Greater
Hume
Council

Greater Hume Council Endorsed Submission to the Environmental Impact Statement (EIS) – Culcairn Solar Farm (SSD 10288)

20 February 2020

PLAN 1:2000 @ A1

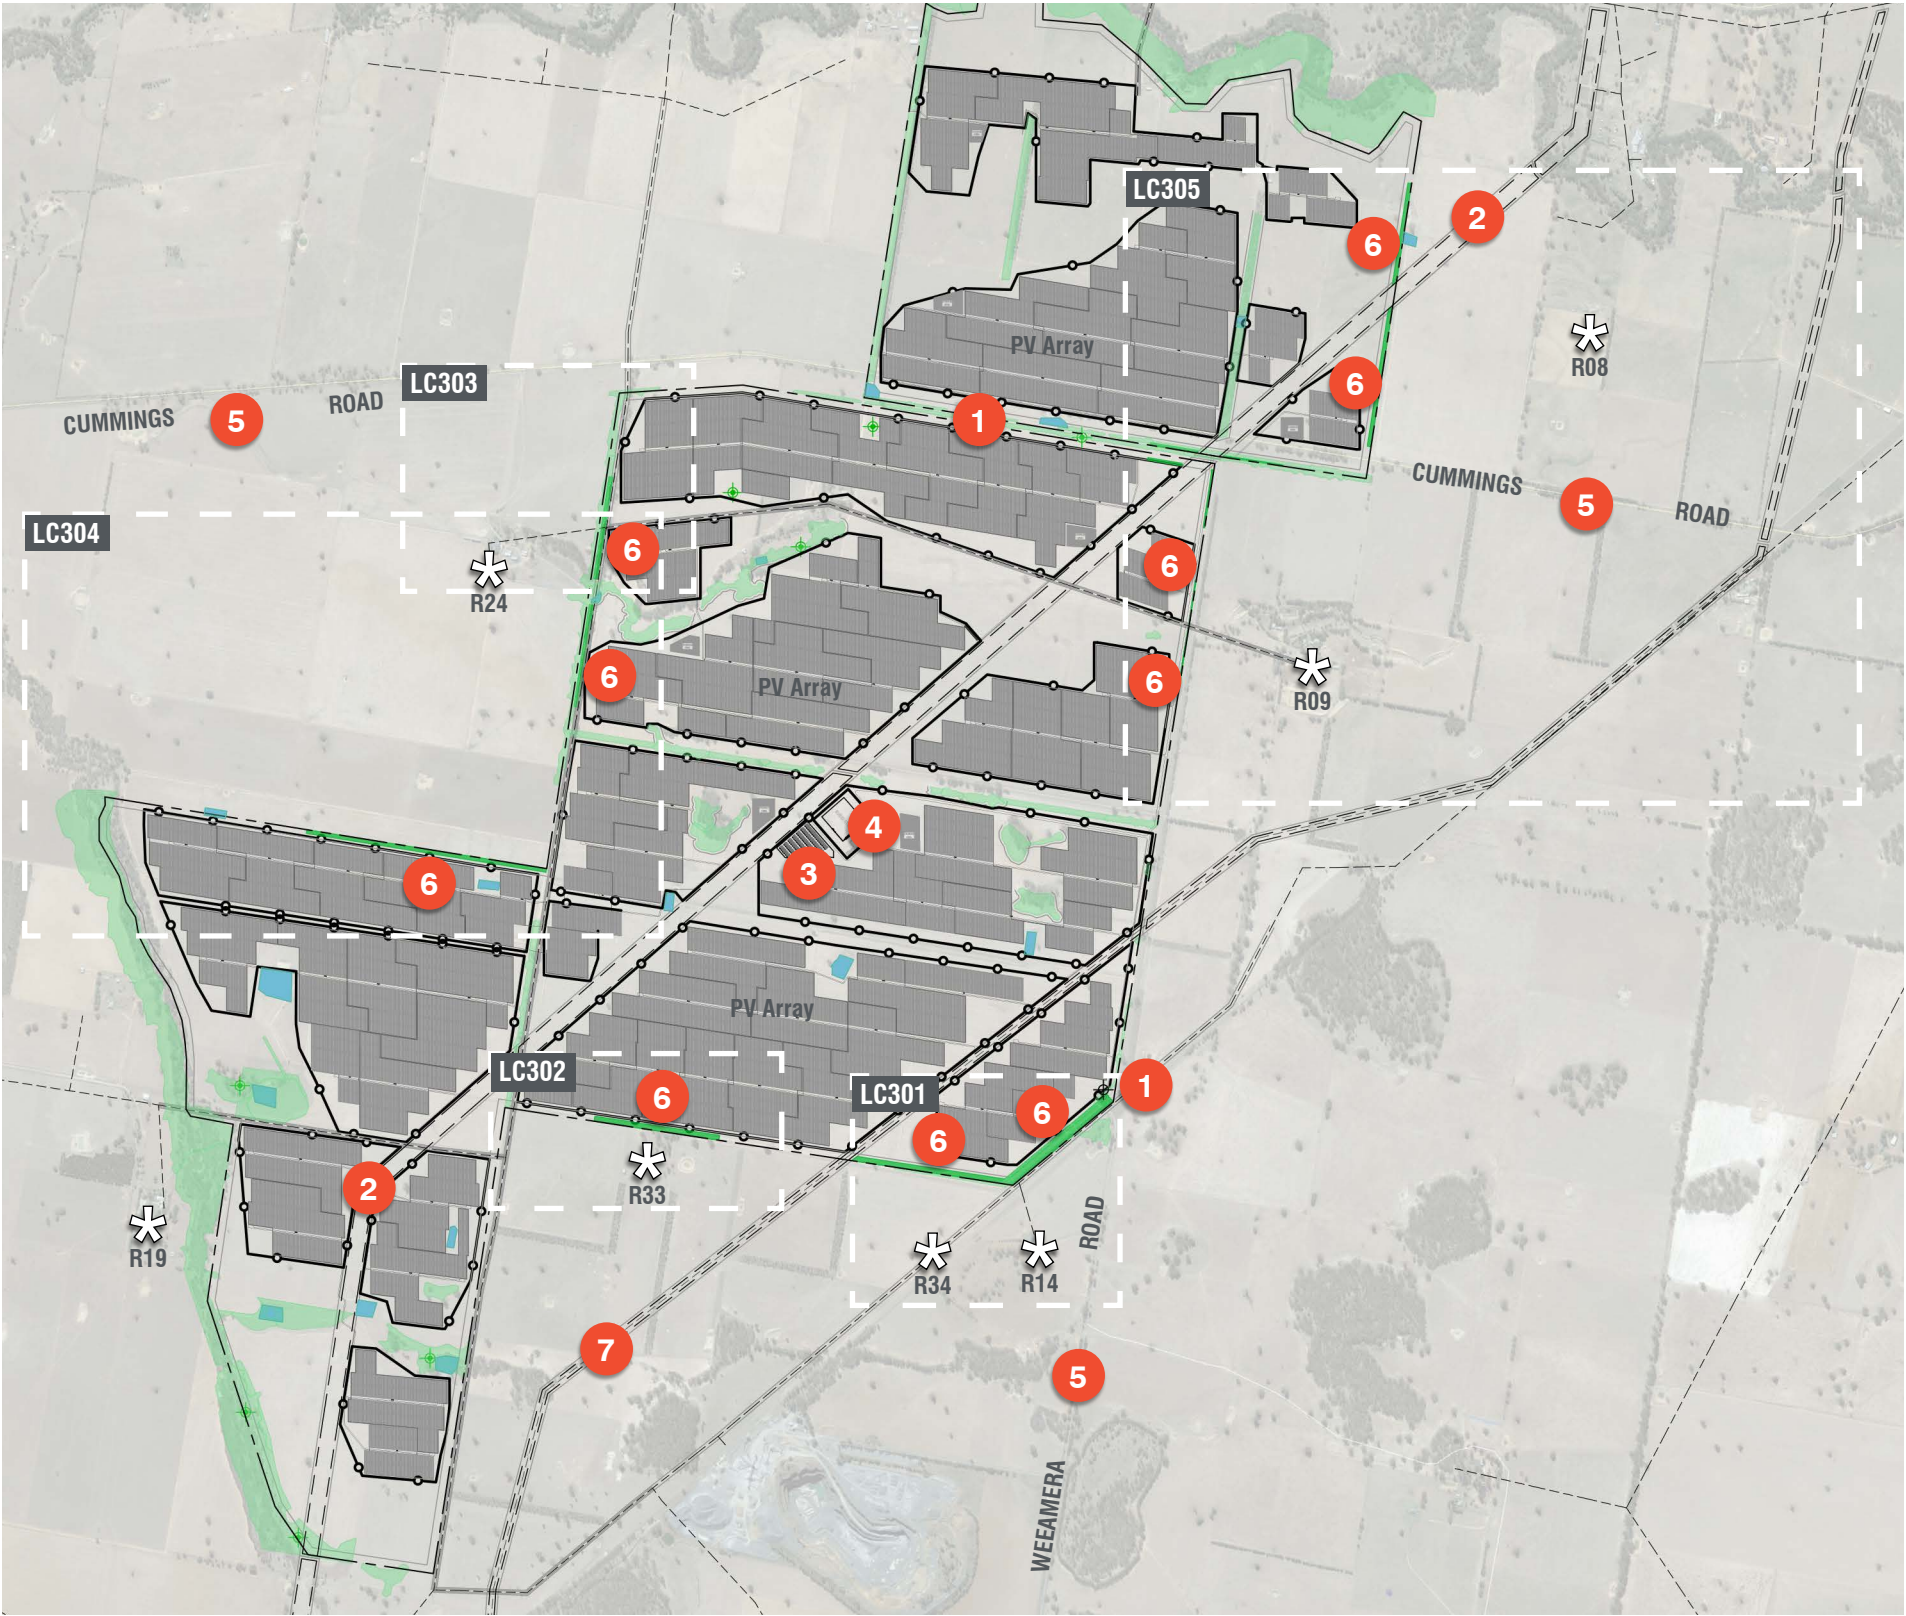
One residence (R14) will initially be subjected to a high inherent visual impact which will reduce to medium visual impact through the mitigation measure of vegetative screening. Council is concerned that it will take many years for the proposed vegetation to be of a sufficient size to mask the appearance of the solar farm and considers that alternatives to mask the view of the development from this residence should be investigated.

- Advanced screening species of two to three year old trees shall be utilised.
- For the period of 1 December to 31 March – a fire unit will be manned onsite with three people to operate a fire tanker.
- A 12 month weed control plan will be prepared and signed off by 2 agronomists.
